WILLOWTREE PLANNING

REF: WTJ23-225

RE: REQUEST FOR ADDITIONAL INFORMATION - CROWS NEST - OSD - SITE B (SSD-61400212)

9 SOLAR ACCESS - L20  
SCALE 1 : 300

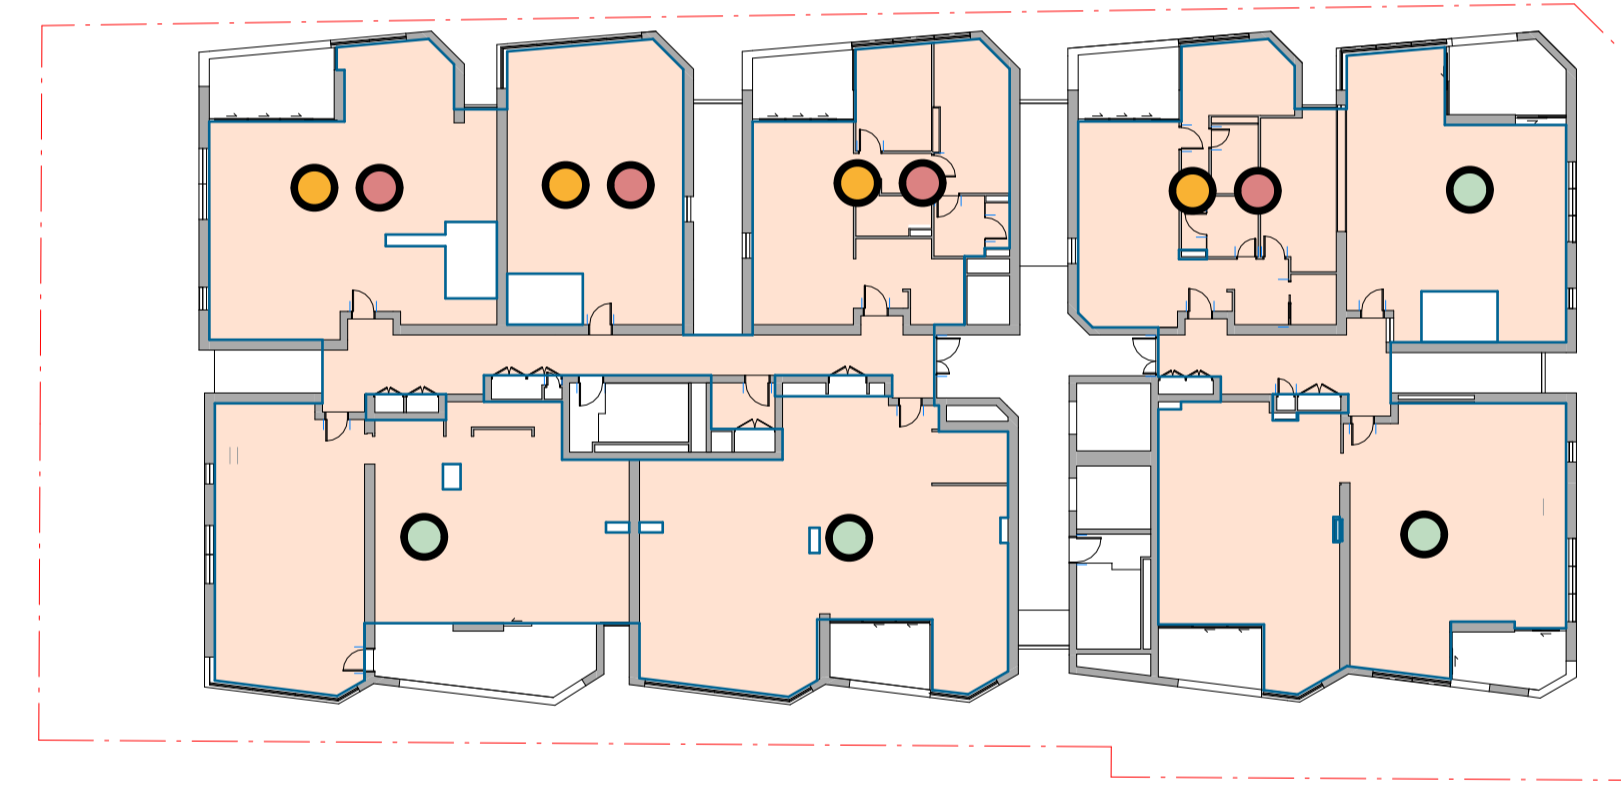
Table 1: Response Matrix	
Department's Comments	Proponent Response
1. Solar Access	
How the proposal maximises solar access, including identifying: i. the number of apartments that receive two or more hours of solar access ii. the extent of solar access received by those apartments that receive less than two hours of solar access; and iii. the extent of apartments that receive no direct solar access.	A detailed solar access assessment has been undertaken in accordance with the ADG requirements (see Appendix 1). The assessment identifies as follows: • 72 units (59%) receive a minimum of 2 hours sunlight between 9am-3pm at mid winter. • The extent of solar access received by those apartments that receive less than two hours of solar access is shown in Appendix 1. Non-compliant units on the western façade will achieve approximately 1hr 45mins solar access between 3:15pm and sundown (4:54pm). Non-compliant units at Level 08 on the eastern façade will achieve 1 hour of direct sunlight between 9am-3pm at mid winter. • 46 apartments (38%) receive no direct sunlight between 9am and 3pm at mid-winter, Notwithstanding the non-compliance identified above, the proposal is considered to deliver acceptable residential amenity outcomes on merit, having regard to the following considerations: • The building orientation and envelope has been established through the approved Concept Proposal (SSDA-9579), which limits the scope for achieving full solar access compliance within the detailed design phase. • The apartments achieve exceptional residential amenity through the provision of generous private open space and premium outlook, including expansive southerly views toward the city and Sydney Harbour.

Substantial communal open space is provided at roof level, which receives excellent solar access throughout the day and provides high-quality recreation areas accessible to all residents. These above mentioned amenity benefits appropriately compensate for the reduced solar access to affected apartments. The proposal therefore demonstrates that while numeric compliance with the ADG solar access objective is not achieved, the development delivers appropriate residential amenity through alternative design responses that are consistent with the objectives of the ADG.
